from
**Southern
Water**

Your ref
AL/121/21/PL

Proposal: Demolition of swimming pool buildings and erection of 1 No. new dwelling using the existing access. This site is in CIL Zone 2 & is CIL Liable as new dwelling.

Site: AL/121/21/PL: - Rear of Green Gables Northfields Lane Westergate PO20 3UH.

Site Plan

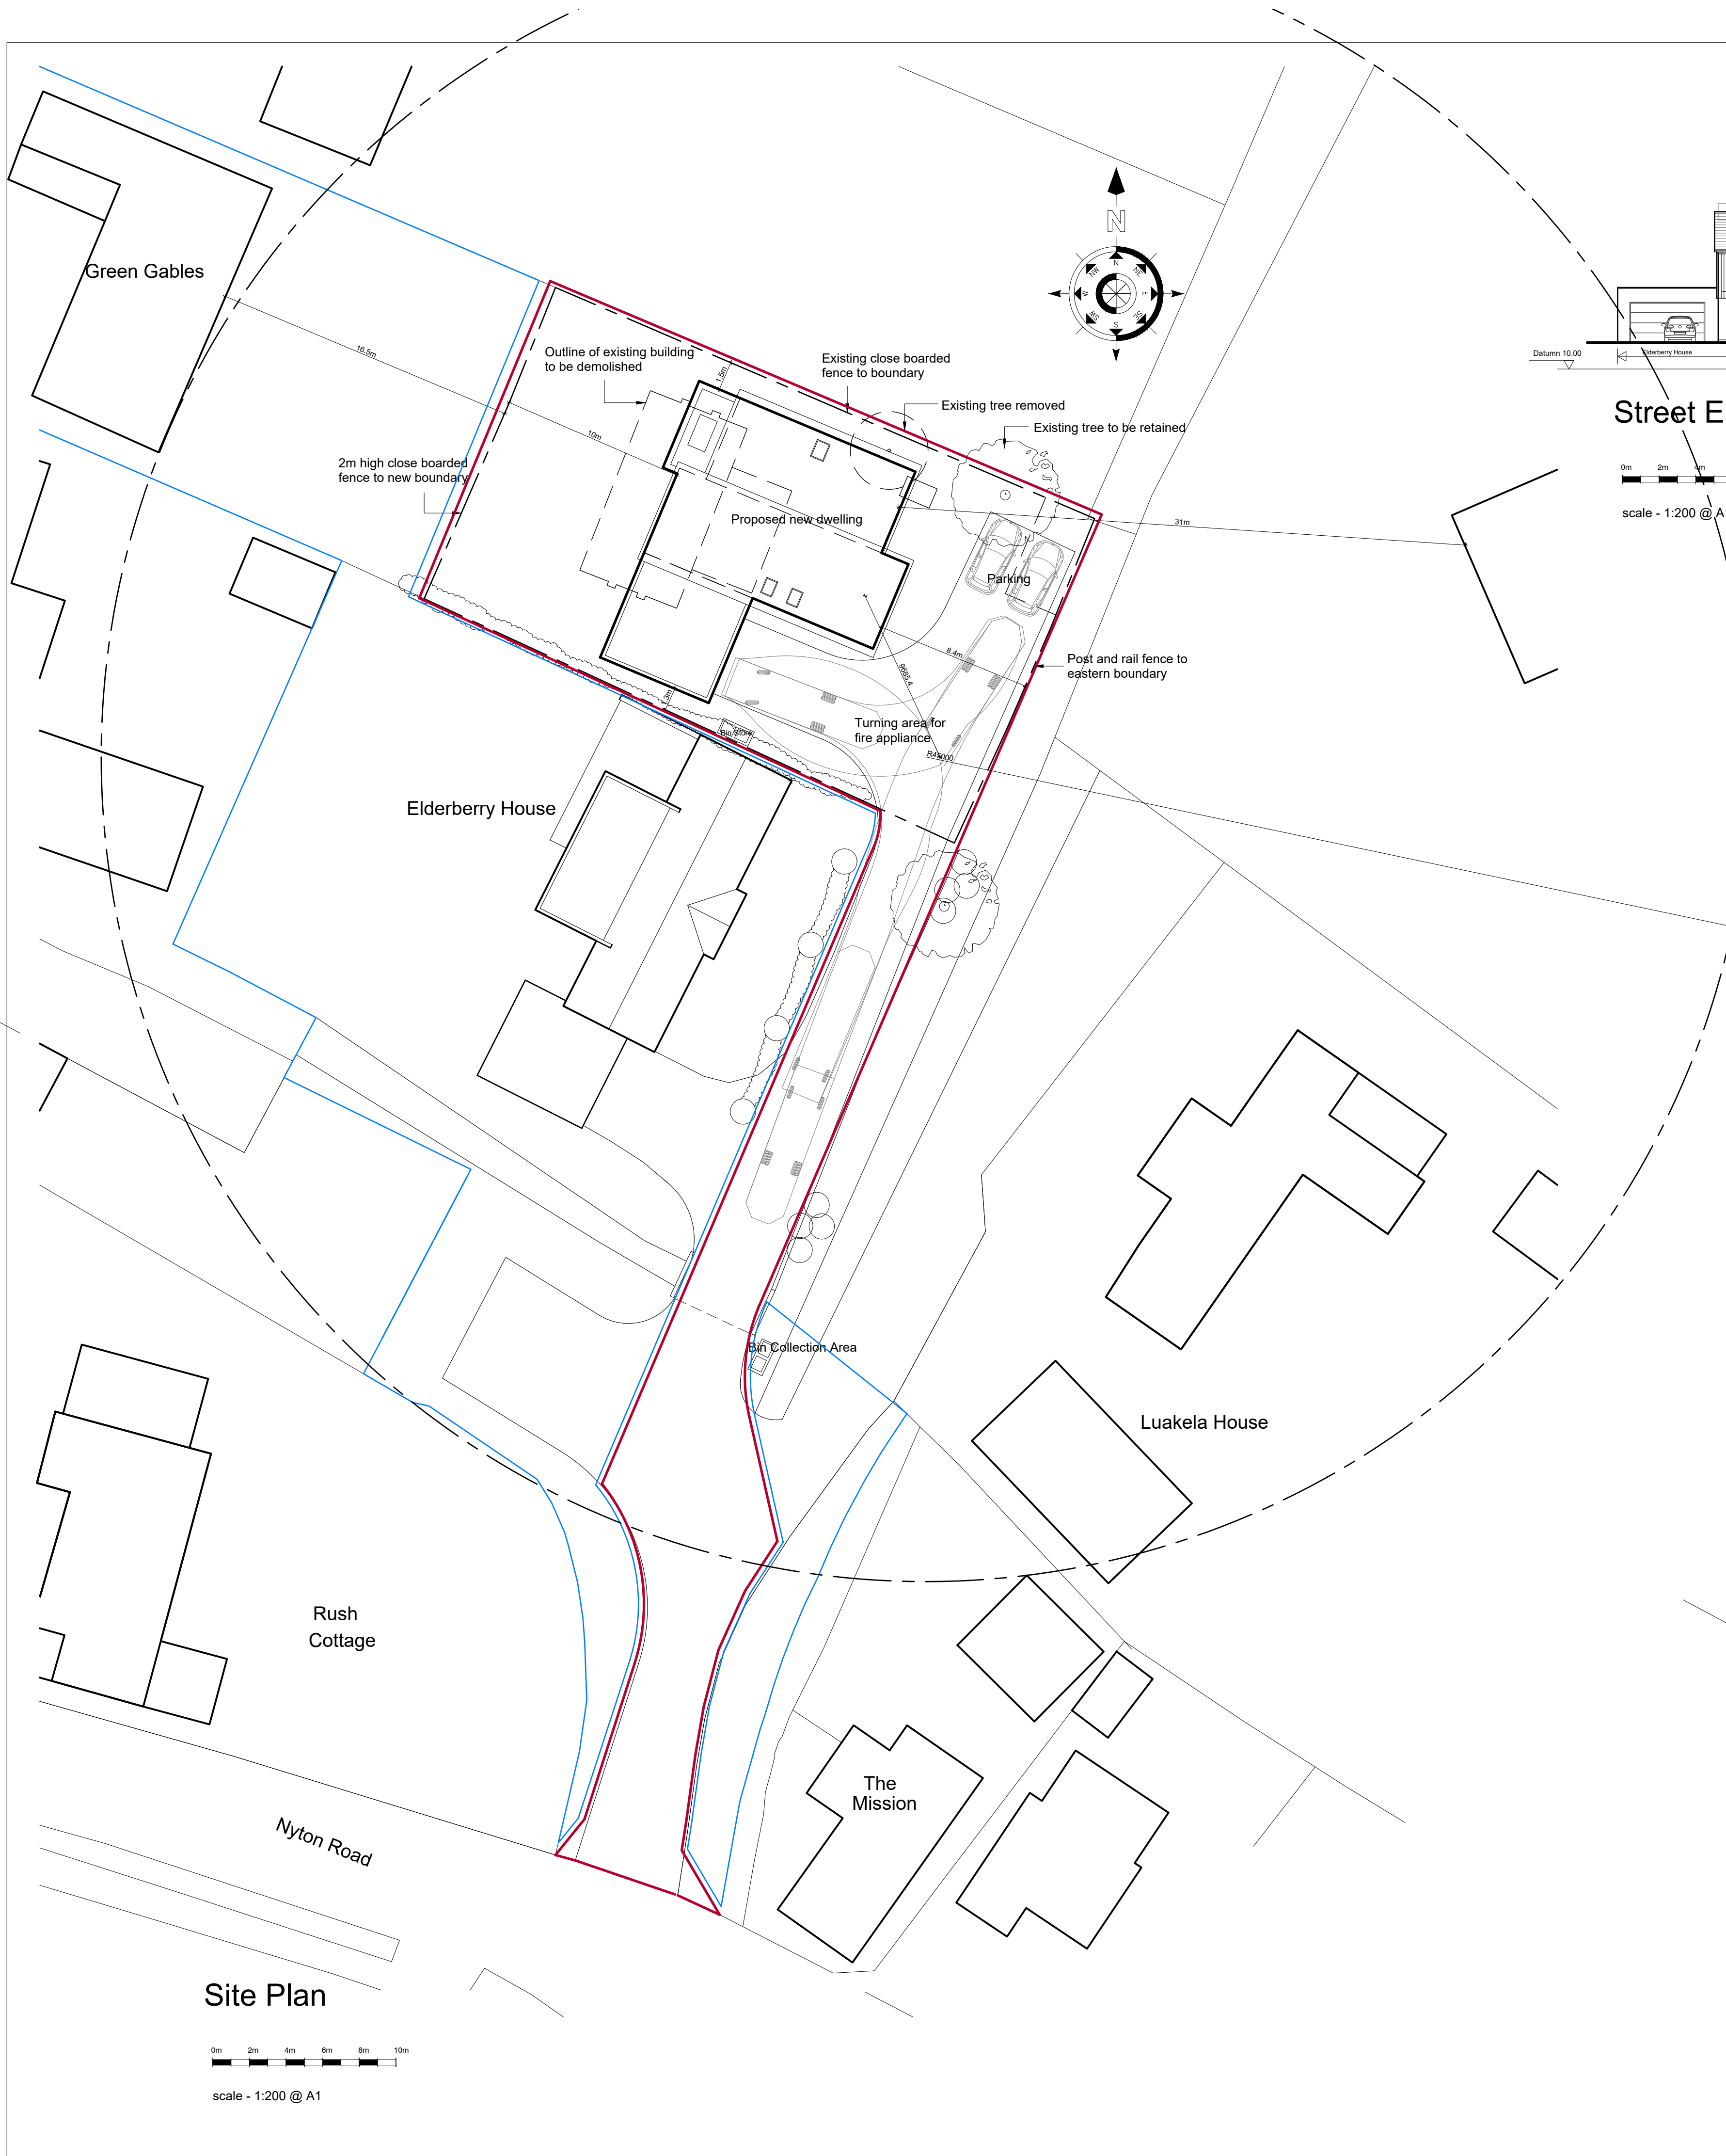
Please see the attached extract from Southern Water records showing the approximate position of our existing foul sewer within the access of the development site. The exact position of the public assets must be determined on site by the applicant in consultation with Southern Water before the layout of the proposed development is finalised.

- The 150 mm public foul sewer requires a clearance of 3 metres on either side of the public foul sewer to protect it from construction works and to allow for future maintenance access.
- No development or tree planting should be carried out within 3 metres of the external edge of the public foul sewer without consent from Southern Water.
- No soakaway, swales, ponds, watercourses or any other surface water retaining or conveying features should be located within 5 metres of a public foul sewer.
- All existing infrastructure should be protected during the course of construction works.
